Recommendation Report for Planning Permission for Works or Extension to a Dwelling

REF NO: BR/357/19/HH

LOCATION: 5 Mons Avenue
Bognor Regis
PO21 5JL

PROPOSAL: Proposed rear extension and loft conversion.

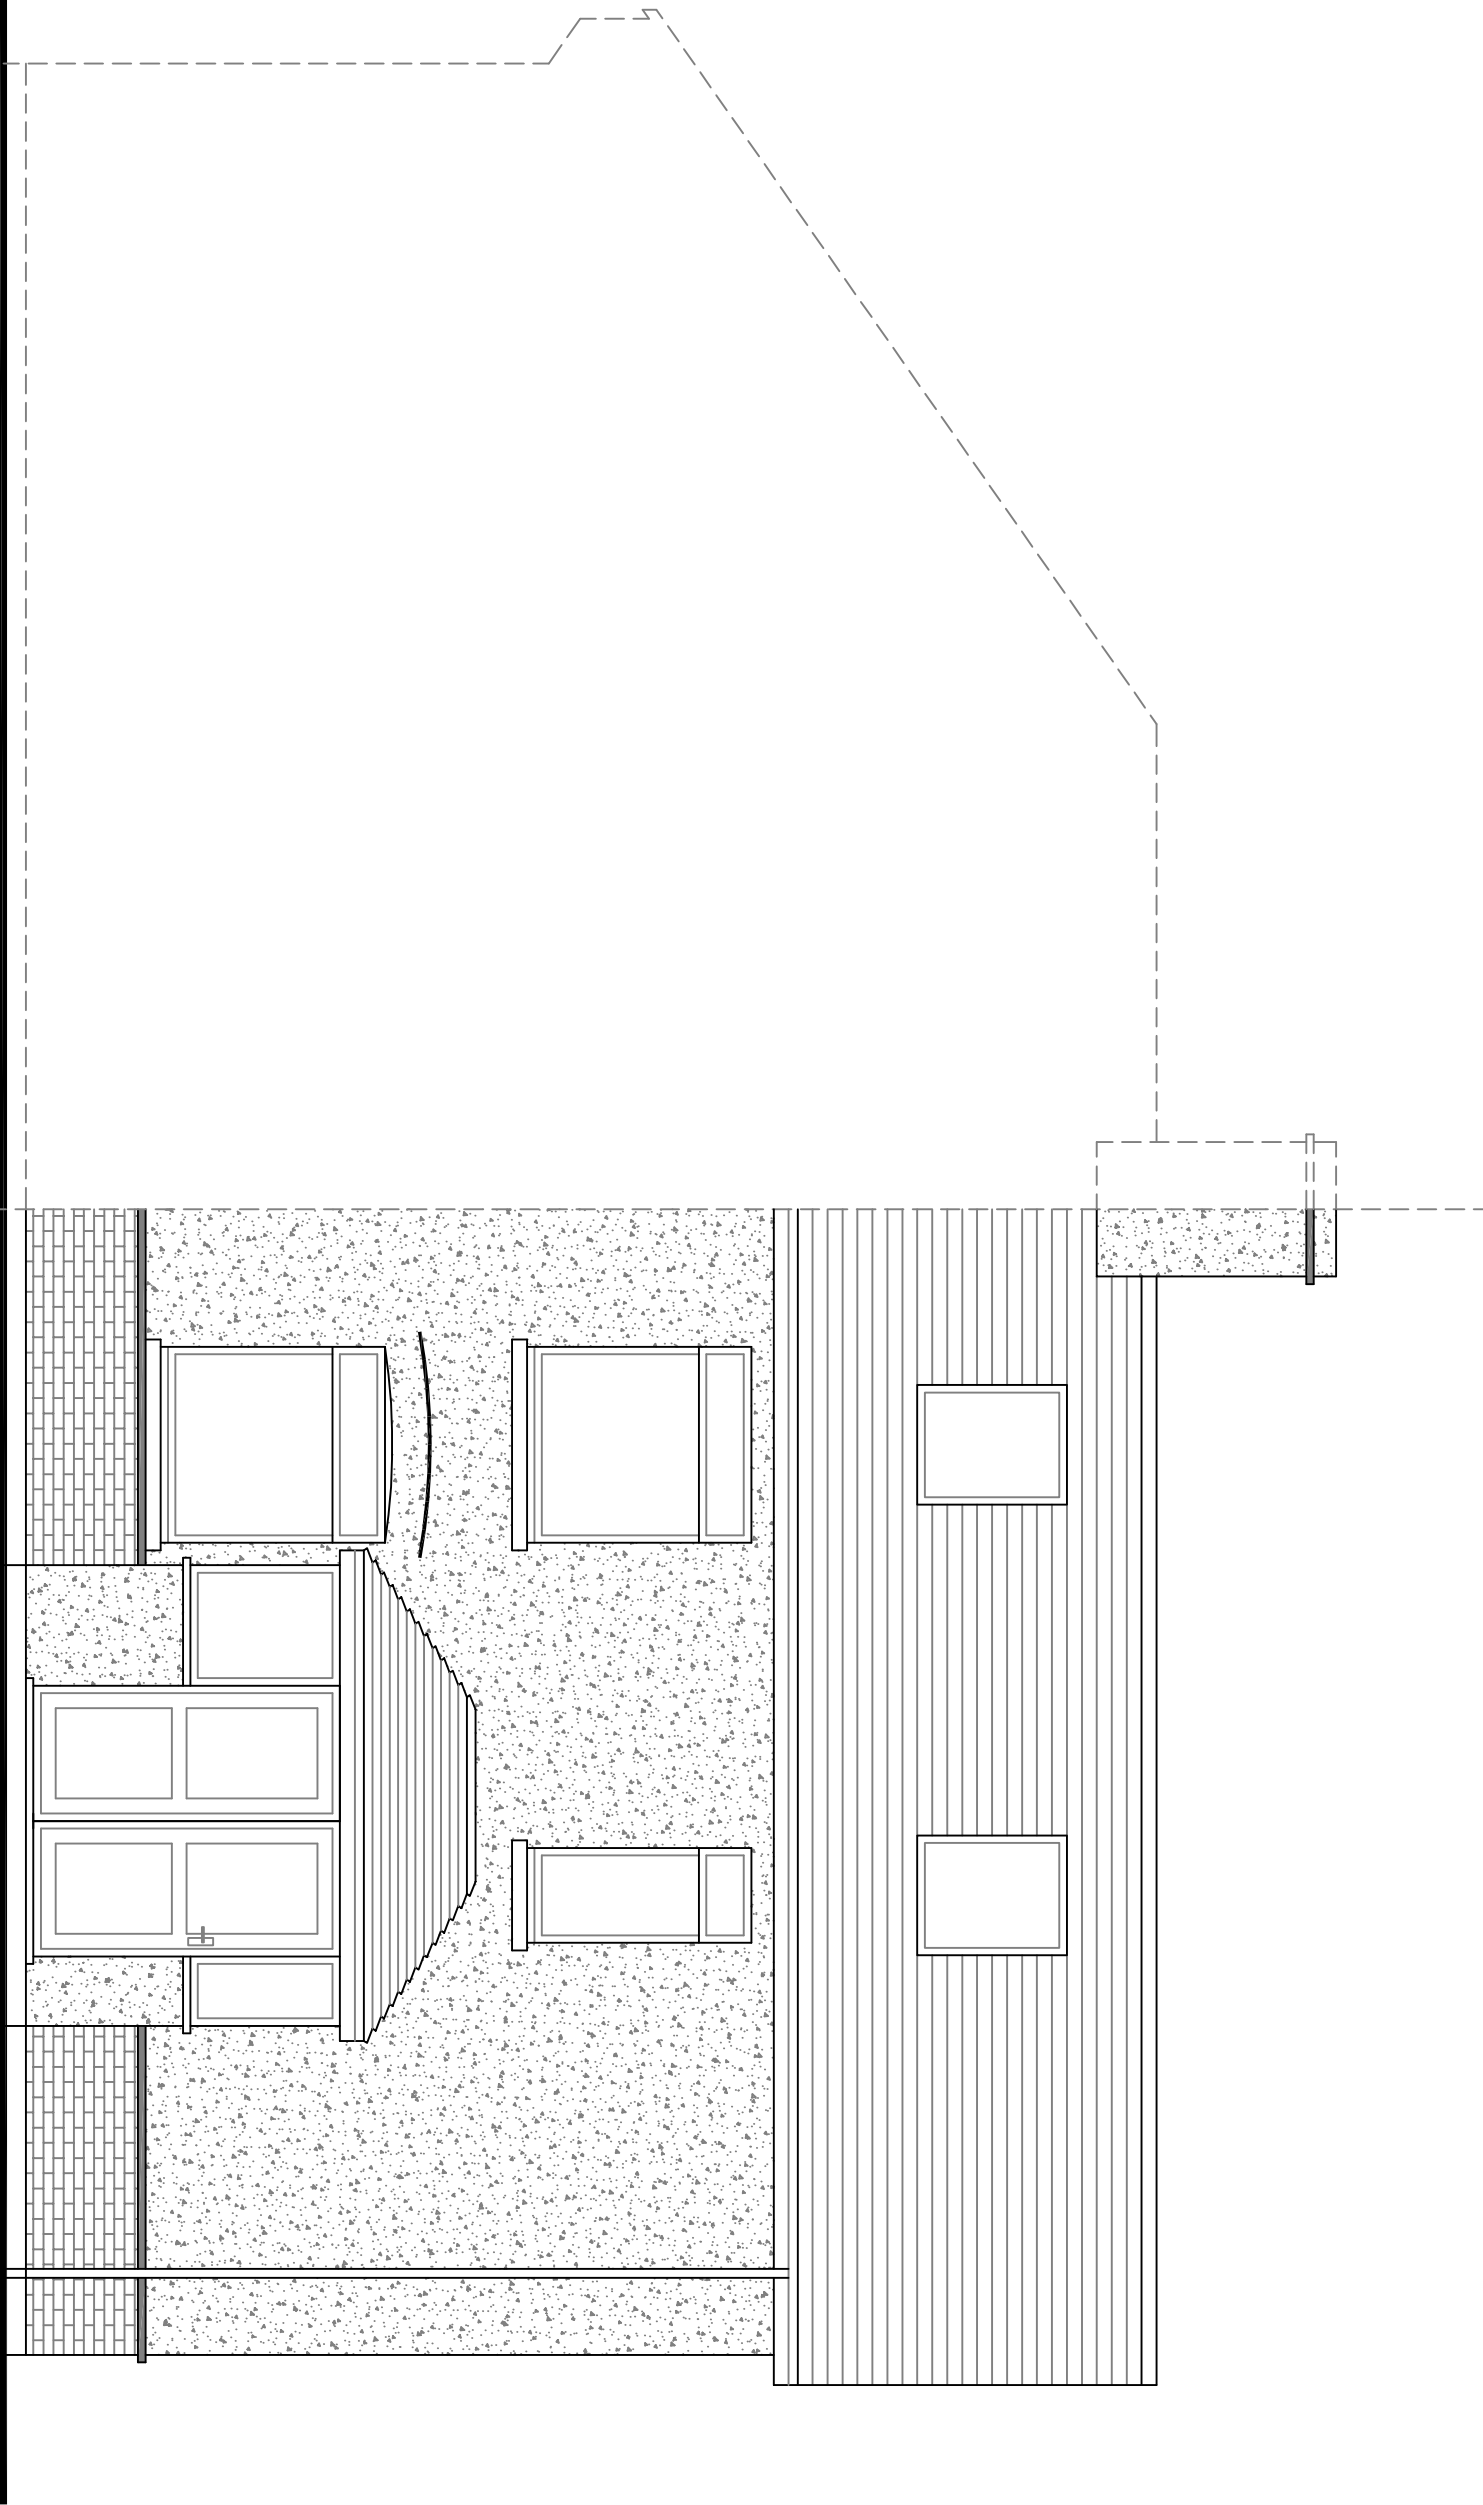
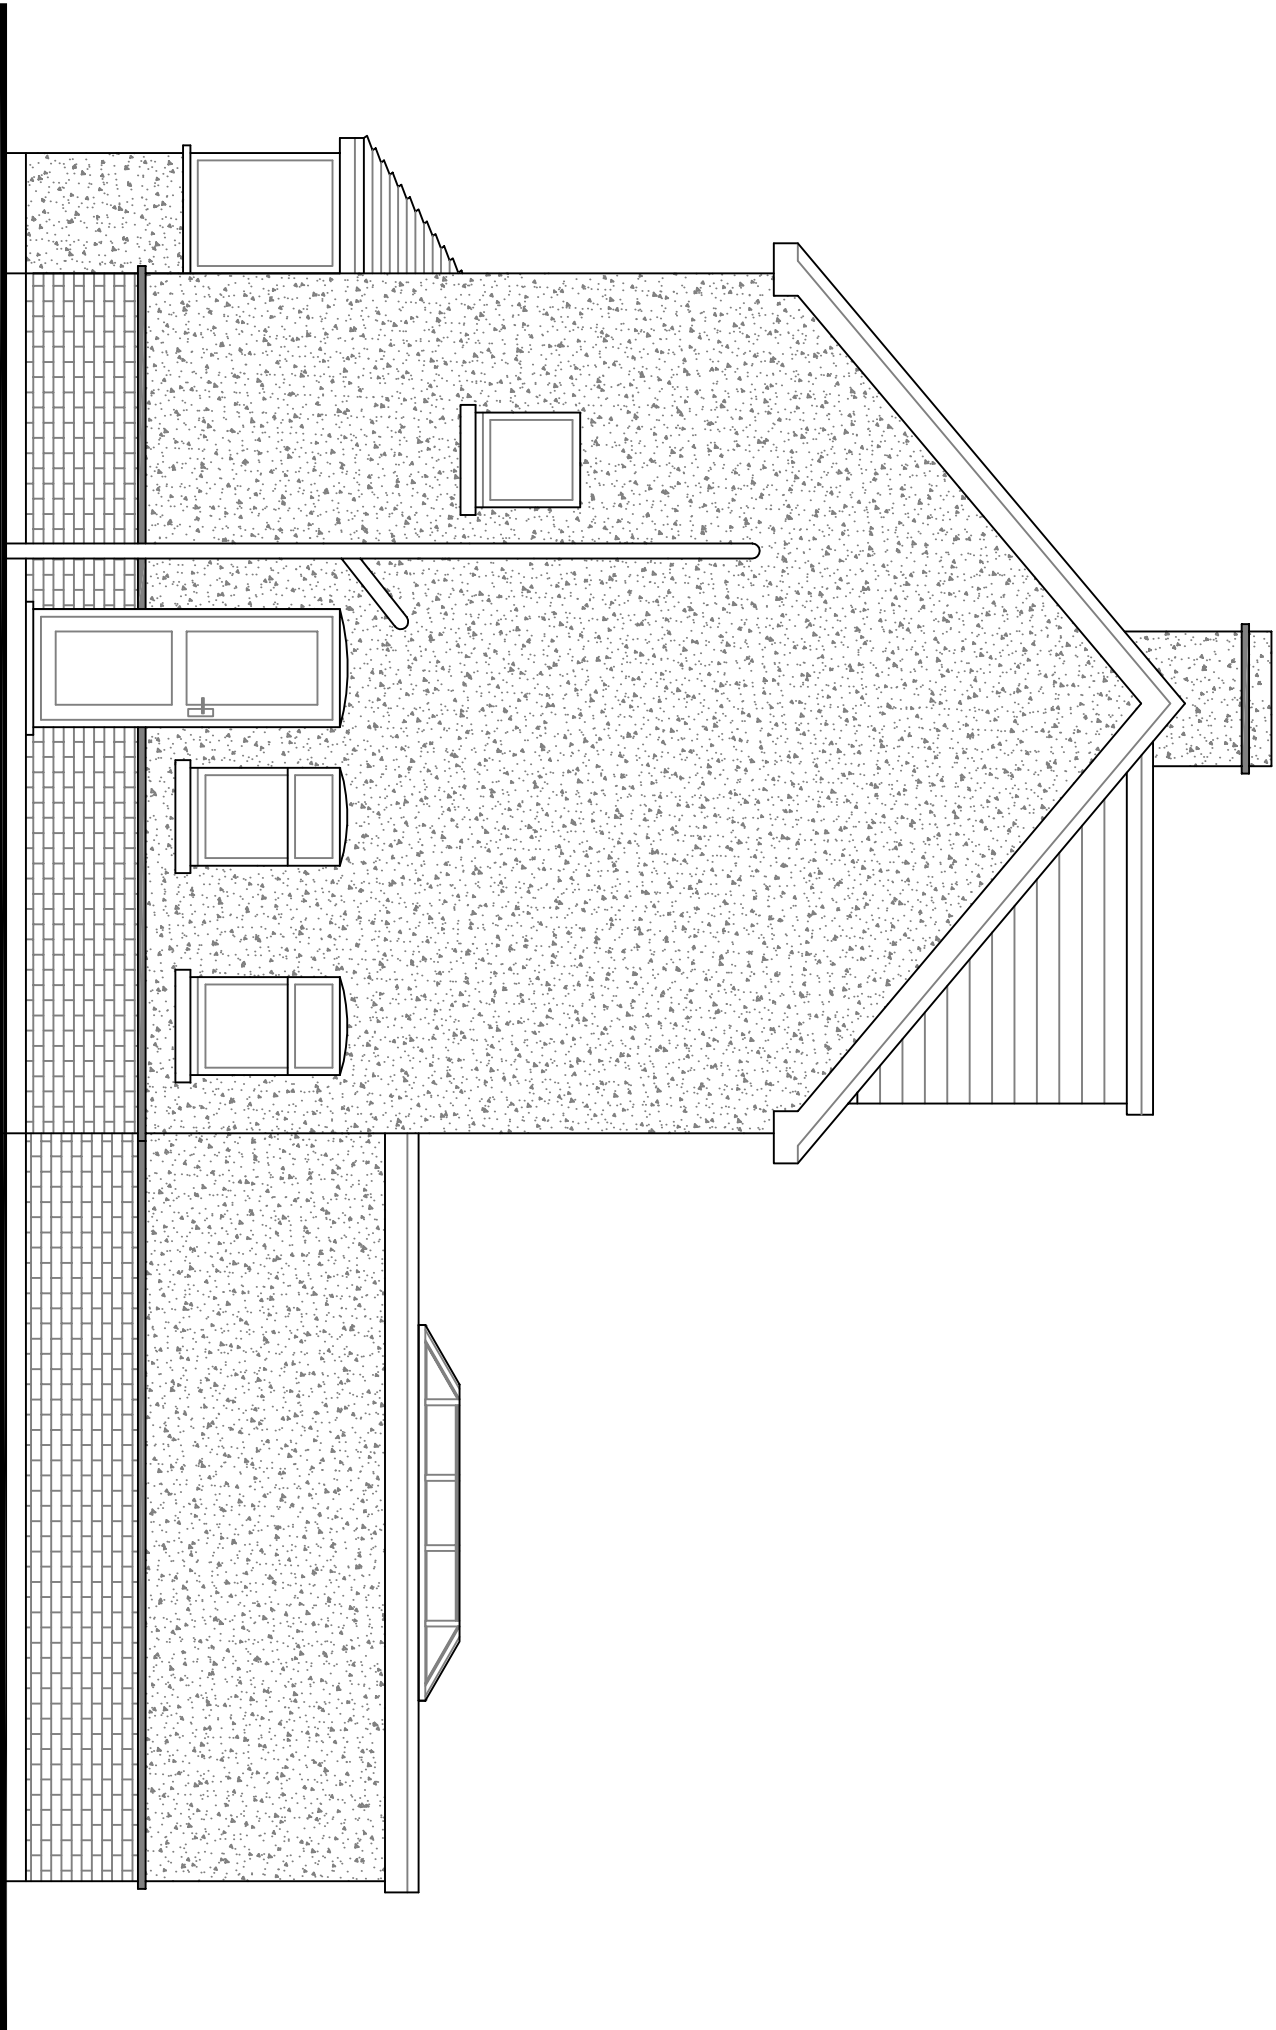
The extension and dormer will be situated to the rear of the property and is not likely to be visible from the wider area. To allow for the dormer, the roof will alter from hip to gable and therefore this element will be visible from the street scene.

The surrounding properties are similar in appearance with pairs of semi-detached dwellings, however the roof alteration is not considered to result in the property appearing significantly out of character in the area. A hip to gable can also be constructed under permitted development.

The extension to the rear and dormer is considered to appear subservient to the host dwelling and well integrated.
